Application no: **3/2021/1021**

Address: **4 Kayley Terrace Main Street Grindleton BB7 4QX**

Proposal: **Proposed change of use of the ground floor from Class C3 to Class E; from a two bedroom terrace dwelling to a ground floor Local History archive and meeting room and a single bedroom flat on the first floor.**

The Local Highway Authority have viewed the plans and highway related documents and have the following comments to make:

Front Elevation

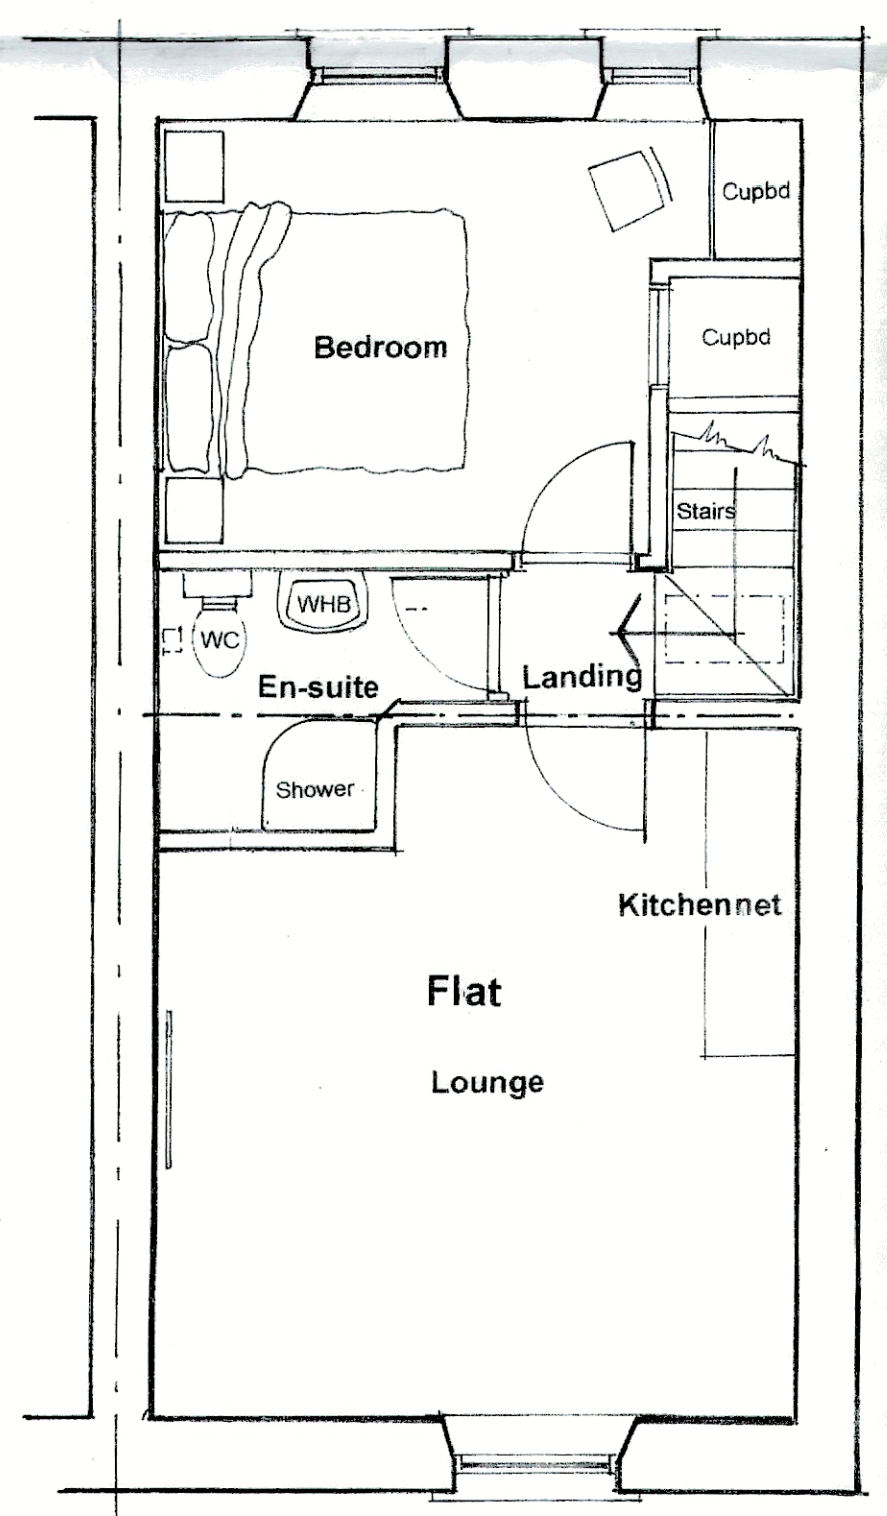
However, the site can only provide one car parking space in the existing single, detached garage and even then, the internal dimensions do not comply with the LHAs guidance, as shown on Jeff Marshall and Associates drawing number 506/1/2 titled "Scheme Drawing", with the LHA requiring a single garage to have the minimum dimensions of 6m x 3m.

However, before the LHA can consider the shortfall in parking at the site with there being a shortfall of 5 car parking spaces for the Local History Archive and meeting room element of the application, the LHA require an Operation Statement stating, *"who will use the meeting room and the Local History Archive; where these people will travel from and how; and the expected trips generated to the site on a daily basis"*. This information will allow the LHA to consider the parking demand at the site.
